Having now read the following documents I would make these observations:

Re Document 8.5.9: Technical Note on Noise Levels at Hintlesham Woods

Re Document 8.5.12: Technical Note on Ancient and Potential Ancient Woodland

Figure 2.3 - Hintlesham Woods SSSI - Ramsey Wood

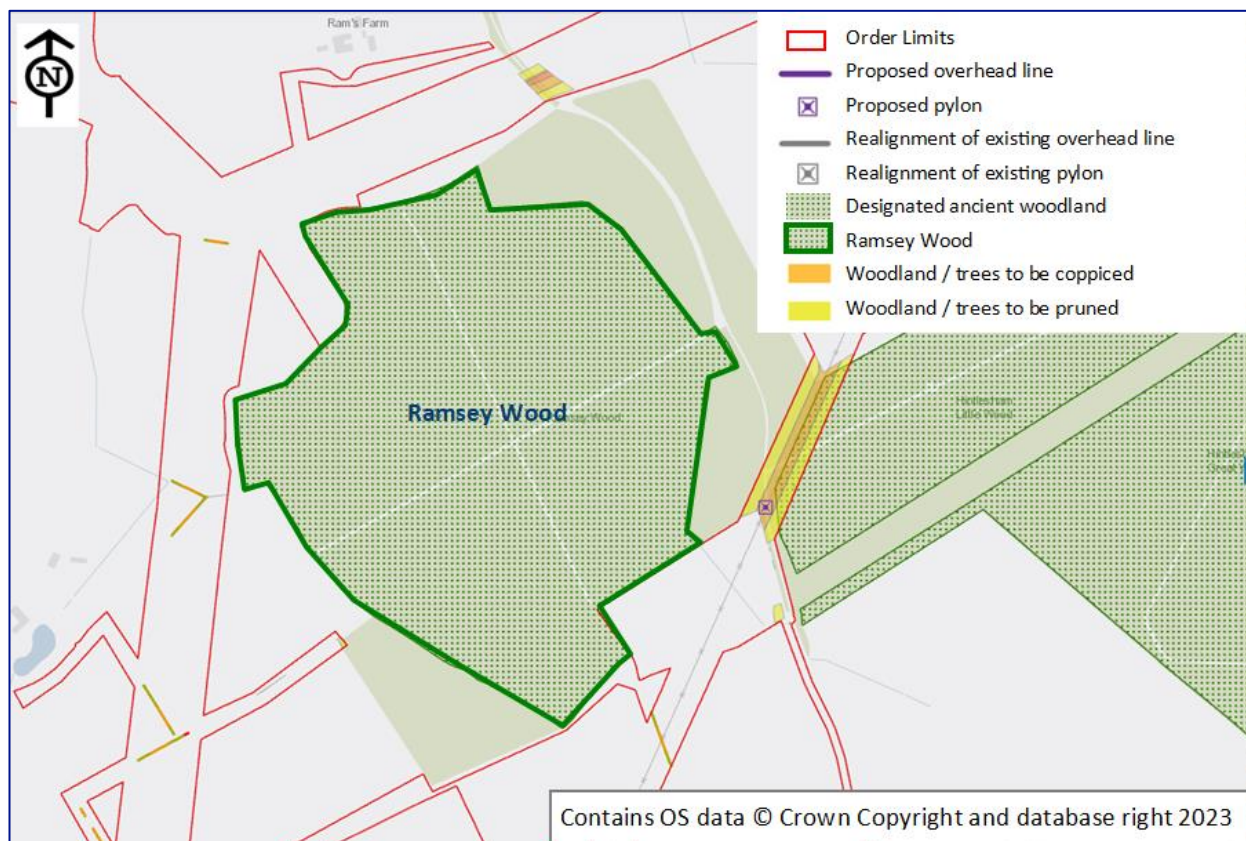
This document - contrary to previous claims and rationale for routing of new lines – at last recognises that the part of the eastern edge of Ramsey Wood / part of Hintlesham Little Wood is not technically ancient woodland. And the very small area taken up for a parallel line oversailing would not need to be valued as such. Locals know this and it is evidenced by old maps and other reports. This was part of my previous assertion during consultation that Option2 - paralleling the existing line and with pylons well outside the woodland – would not be as damaging as an additional line of 4km across virgin territory and still 20m from ancient woodland edge.

In fact, the creation of more high scrub could actually be of more benefit to many species, including nightingales.

Of course, it's better to do neither and underground instead.
